Laurie Leader - RE: Valdmanis 29 Bowdoin

From: "Gary" <Gary@douston.com>
To: "Laurie Leader" <LRL@portlandmaine.gov>
Date: 4/2/2015 2:34 PM
Subject: RE: Valdmanis 29 Bowdoin
CC: <dave@douston.com>

Can you confirm the following:

- REMOVE WOOD FRAMED LOW PITCH SHED ROOF
1. INSTALL COMPACTED GRAVEL FILL RIGIDLY OVER CONG FL WITH DRAIN AND MAHOGANY DECKING PANELS.
  2. TOP OF DECKING TO BE 4" TO 6" BELOW WINDOW SILL.
  3. DECK PANELS TO BE REMOVABLE FOR DRAIN MAINTENANCE.

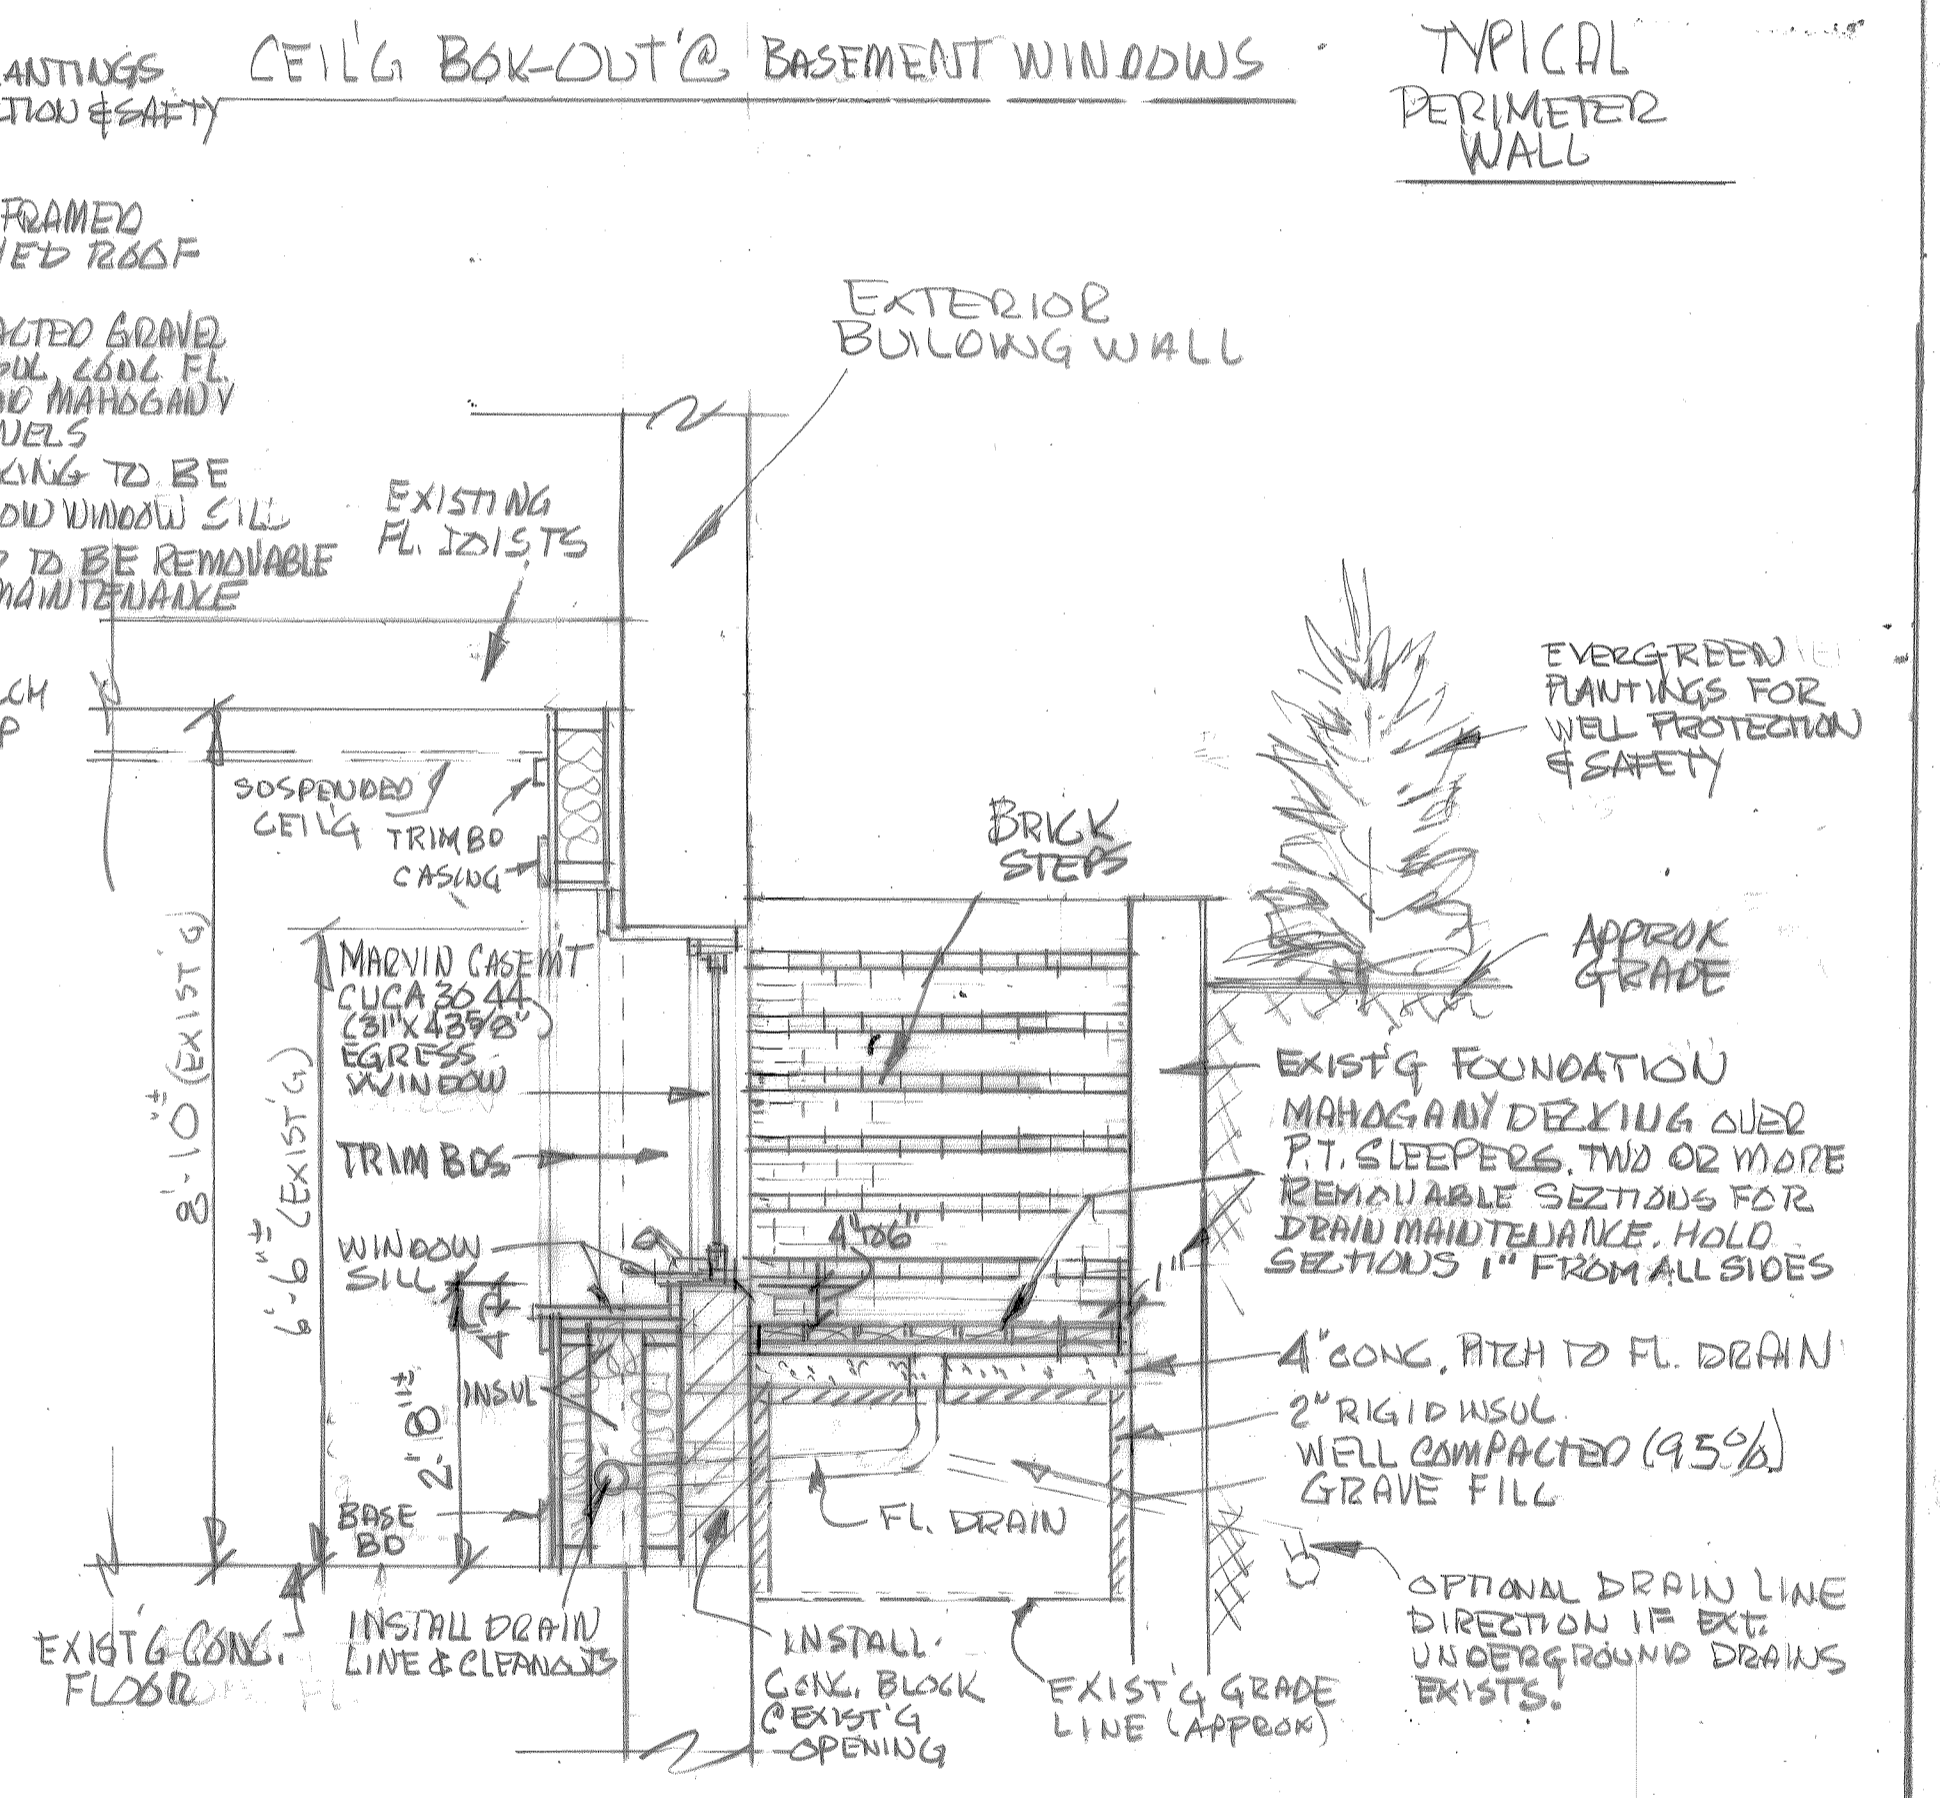
- Do the bulkhead stairs meet R311.7.9.2 Bulkhead Enclosure Stairways? **Yes – it is about 6’ 6” from the concrete floor up to the outside grade.**
- Clarify if the bathroom fixtures meet Figure R307.1 Minimum Fixture Clearances. **As drawn, it is hard to tell if all the clearance distances are met, but we will be sure to lay it out appropriately before we build.**
